## Response to CDC Arboricultural Officer Comments

### Arboricultural impact assessment.

### Arboricultural method statement.

### Ancient woodland.

drawing title  
**Tree Protection Plan  
(Sheet 6 of 7)**

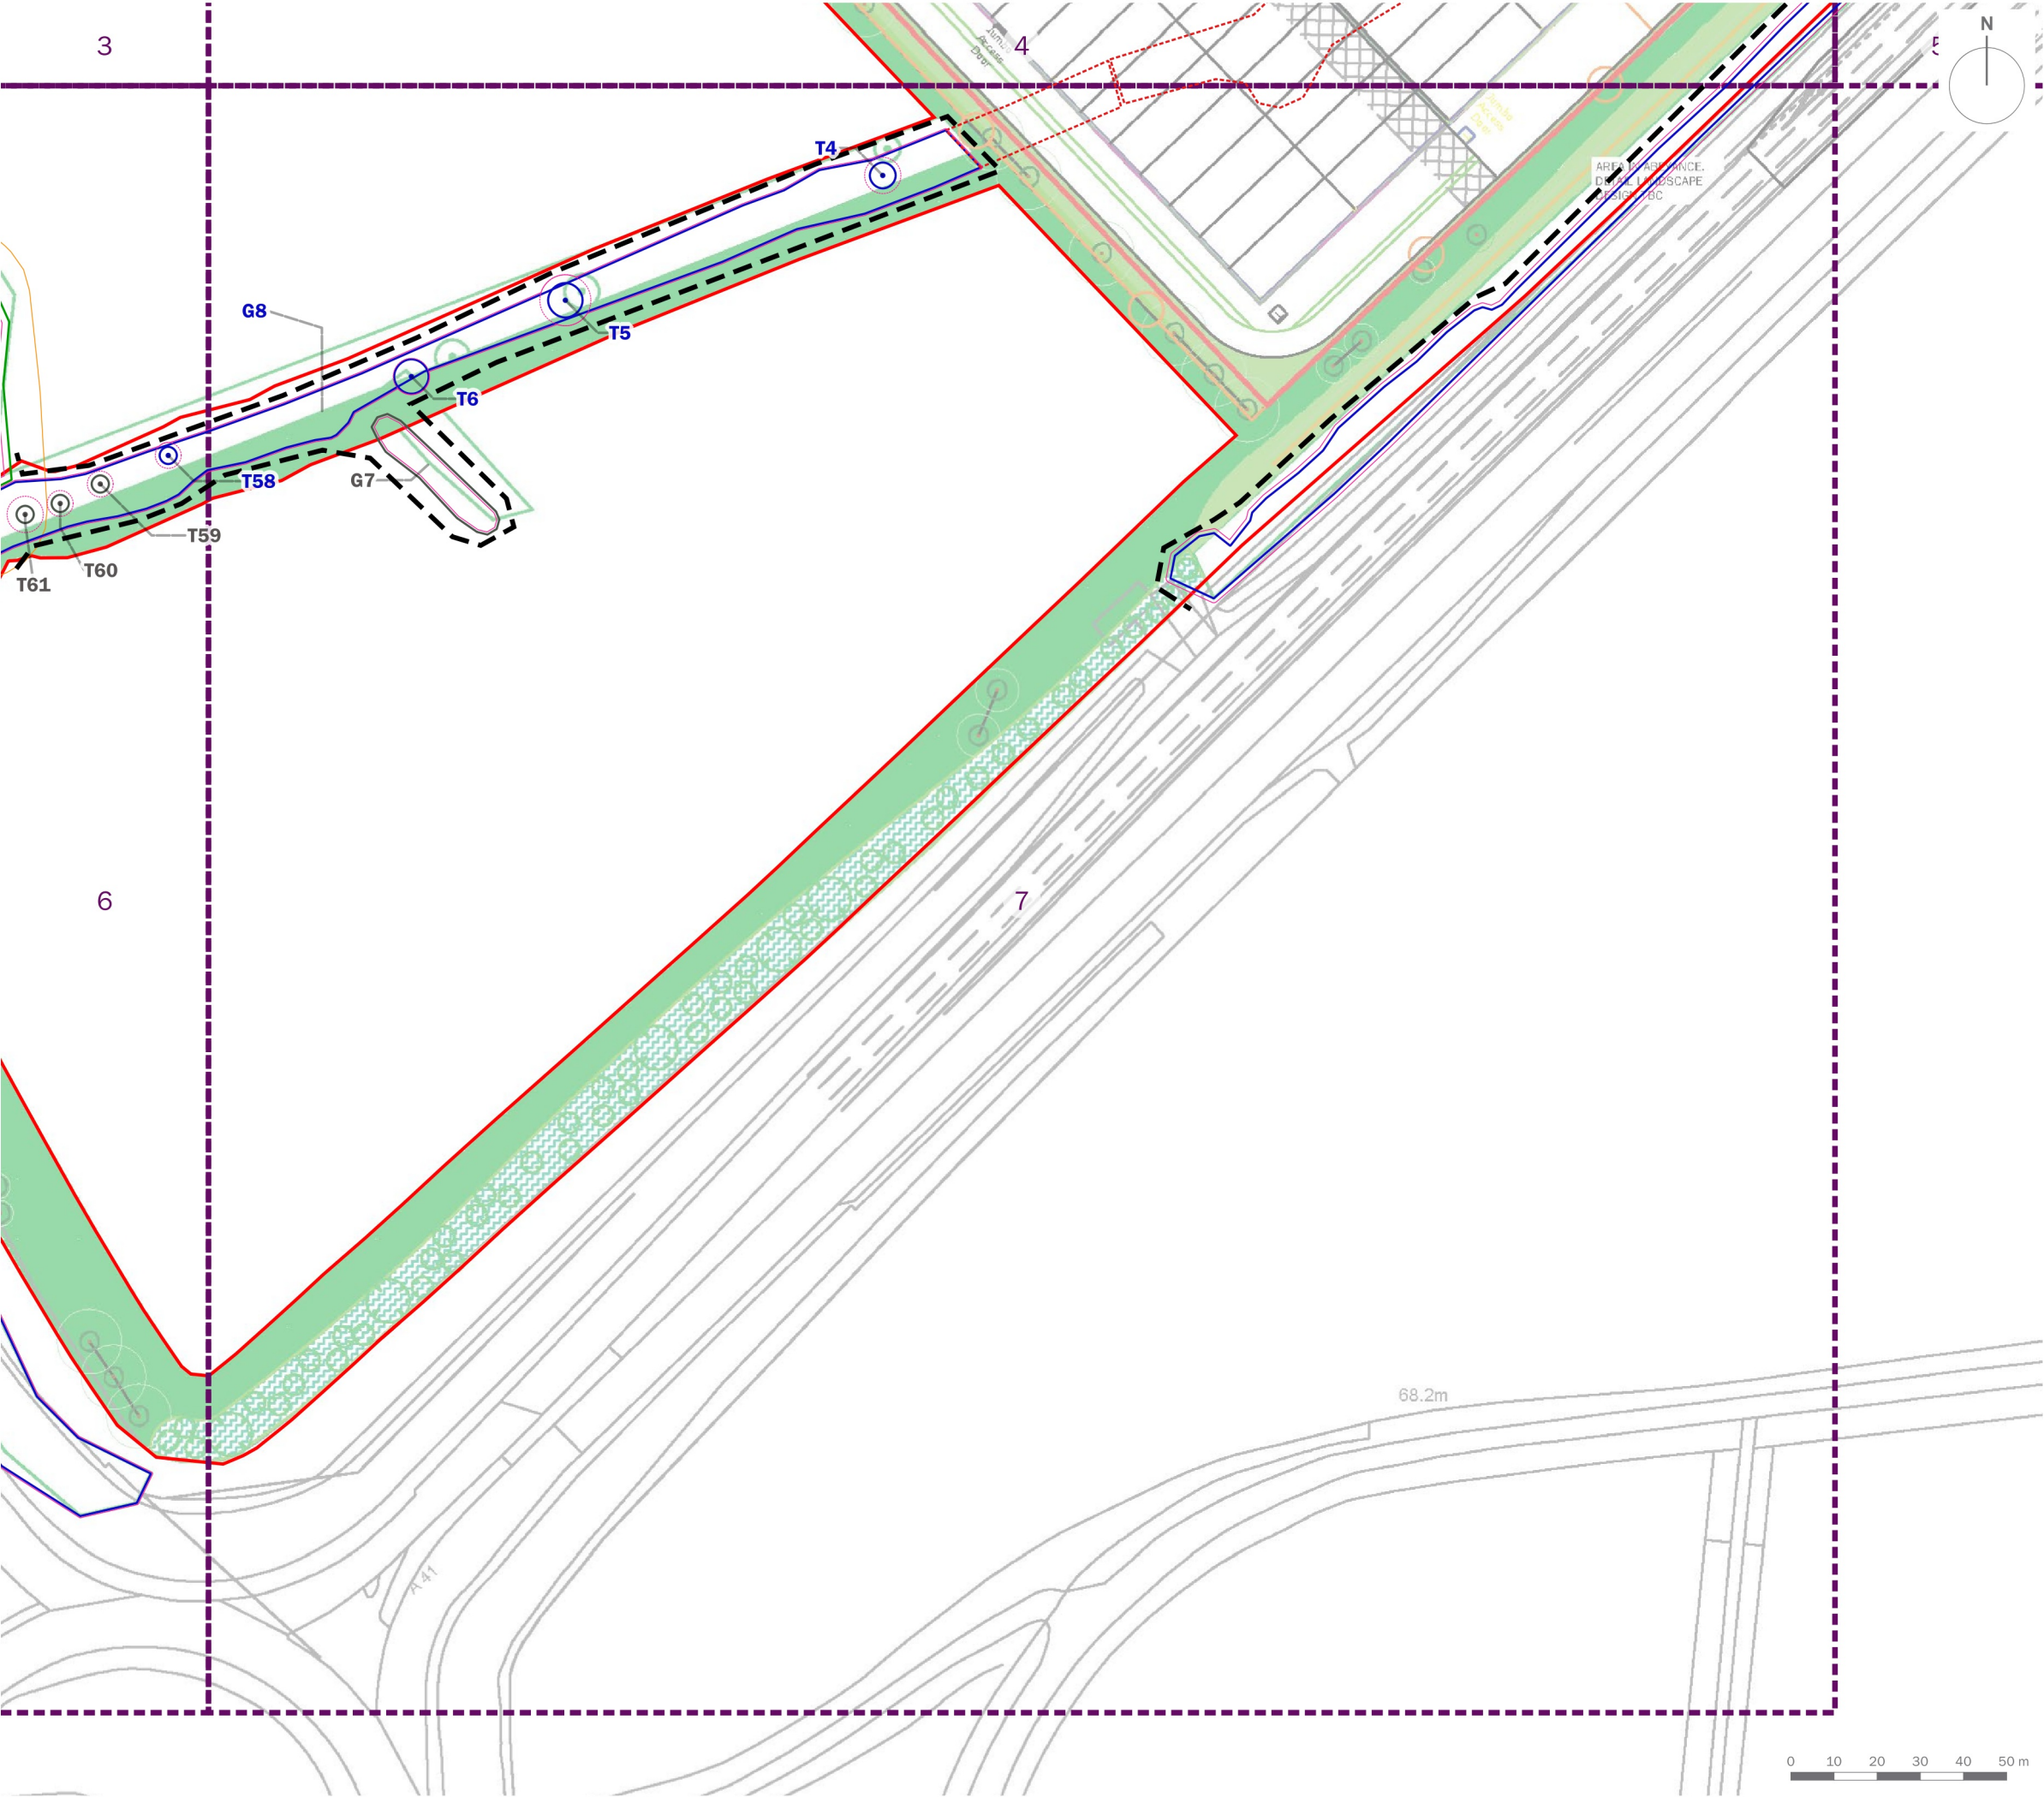
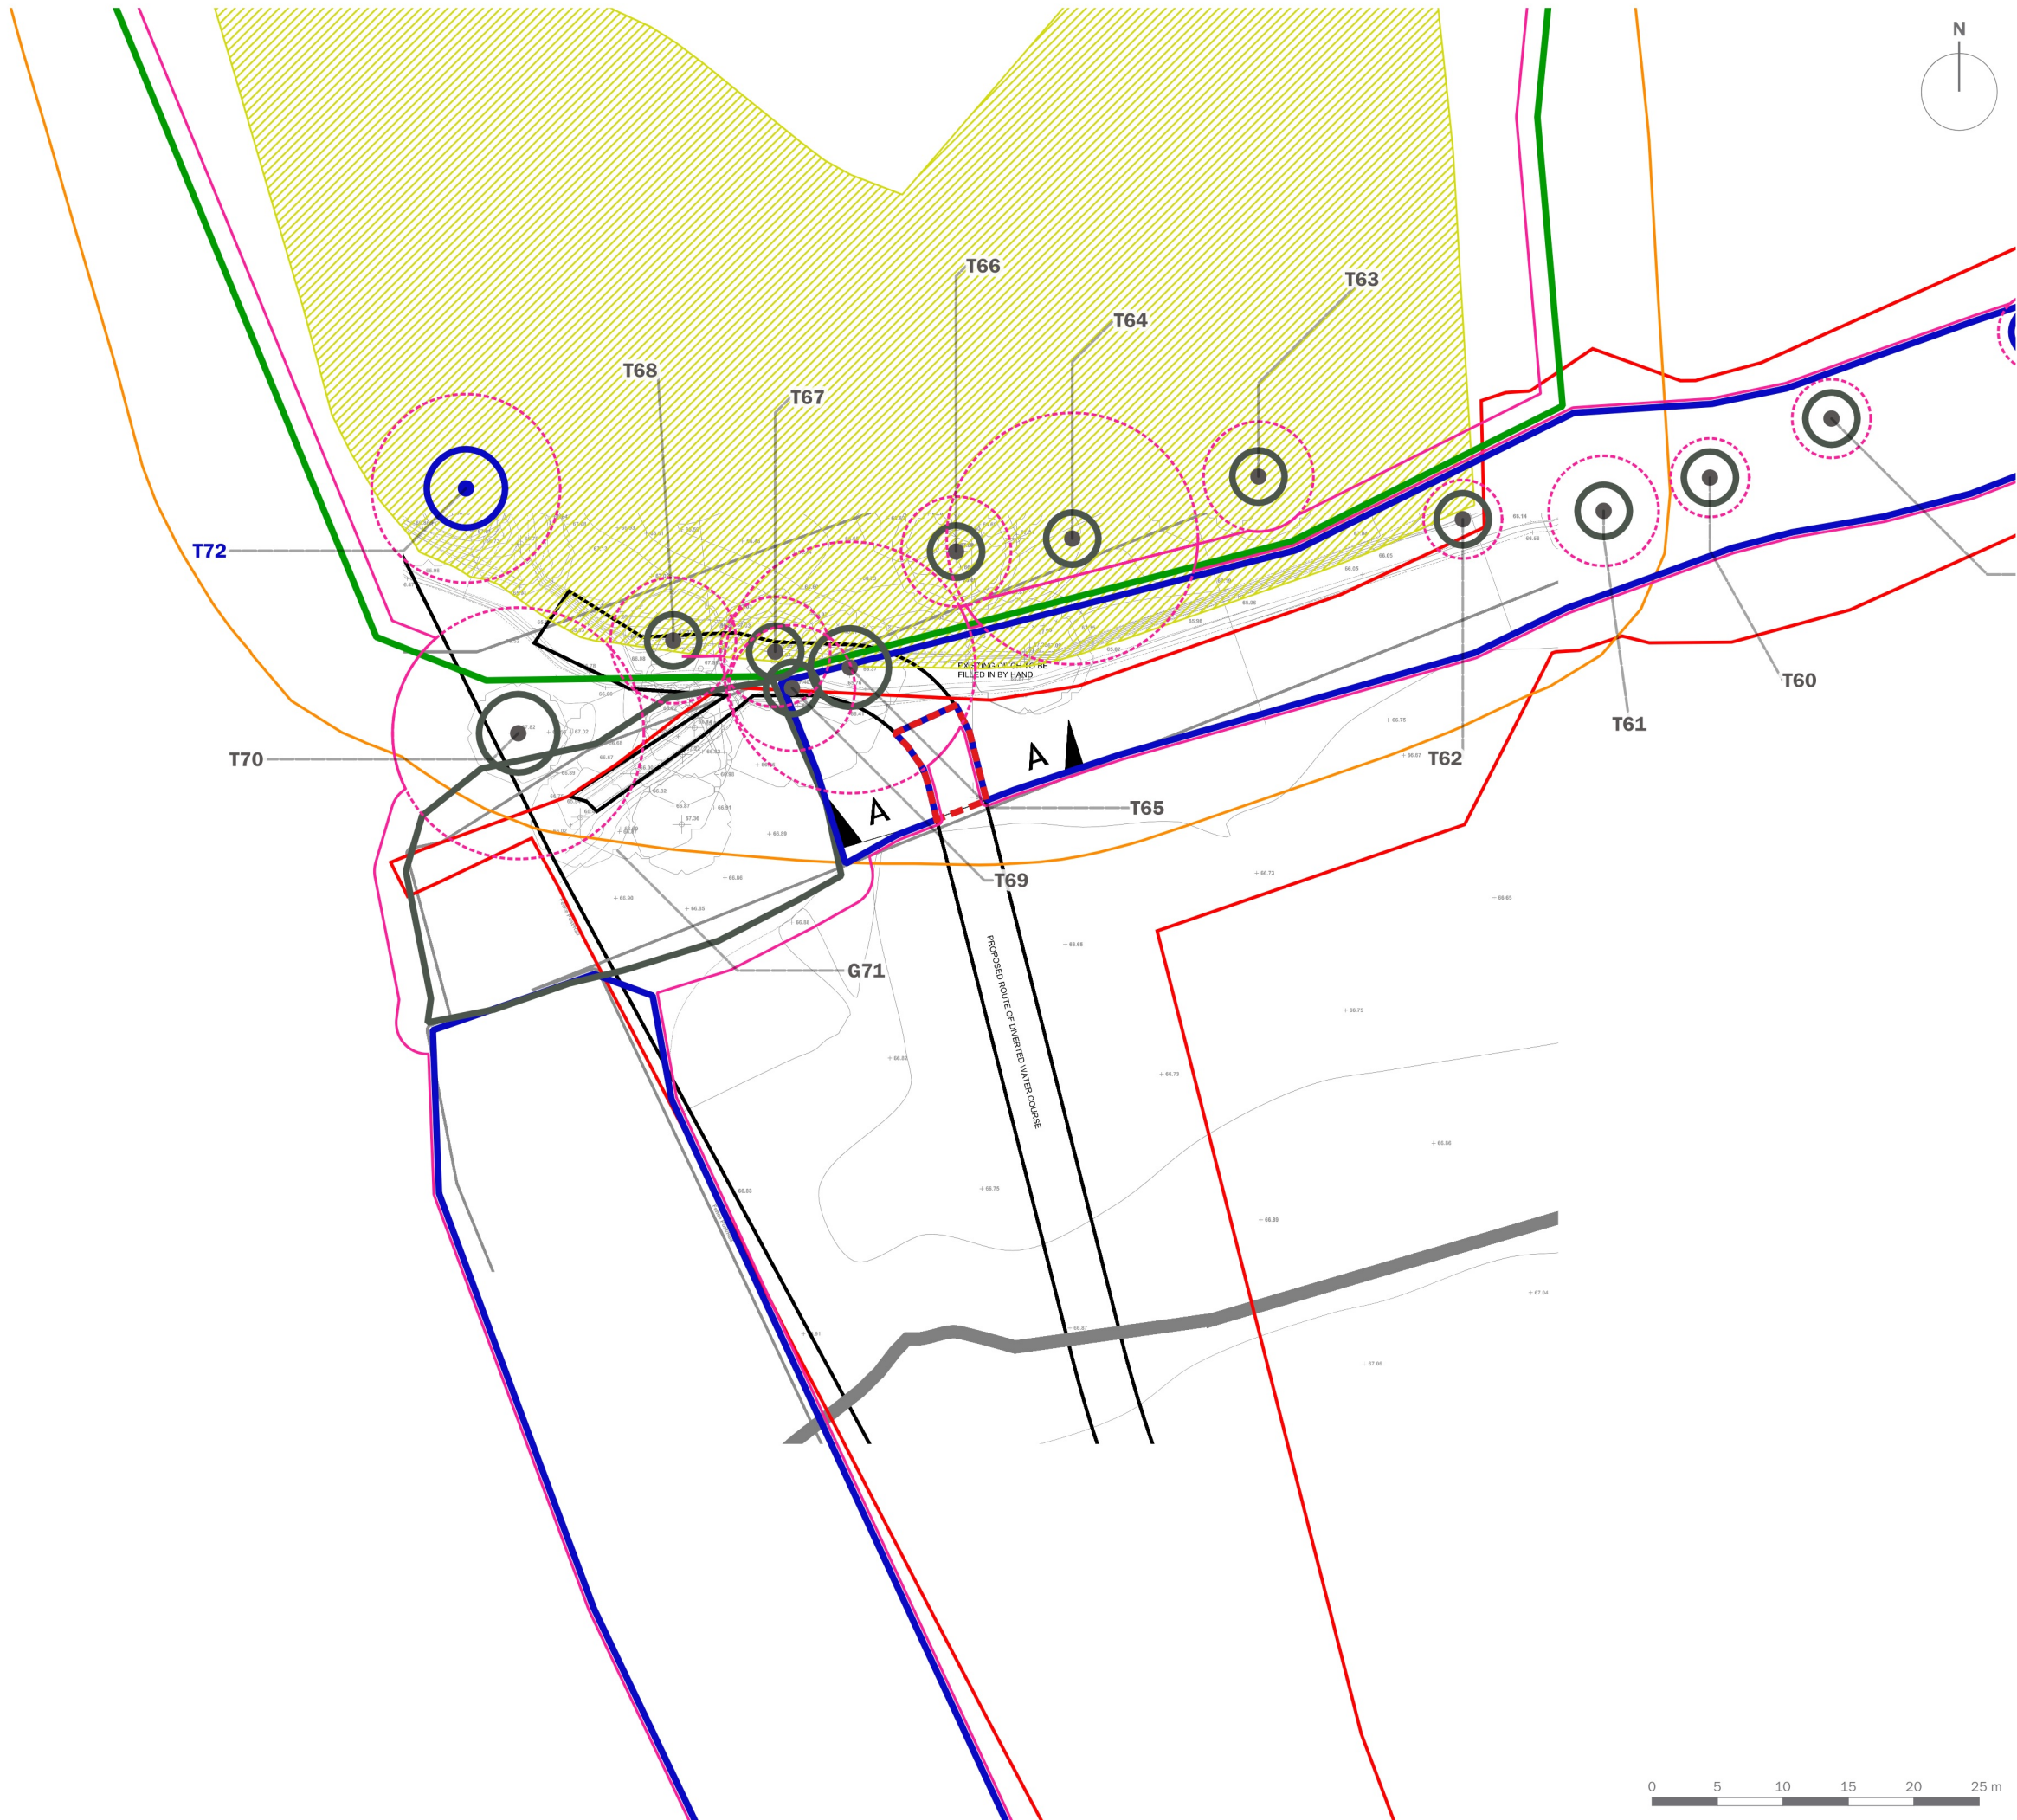
- Confirm justification for T37 removal.
  - T37 is being removed to enable the construction of a bund around the eastern portion of the site. Please refer to the Tree Protection Plan contained within the updated Arboricultural Impact Assessment (June 2022).

- Full AMS/TPP plan including access.
  - The Tree Retention Removal Plan has been revised to a Tree Protection Plan within the updated Arboricultural Impact Assessment (June 2022). Furthermore, protective fencing will be erected within the redline boundary in areas where development should be excluded from RPA's.
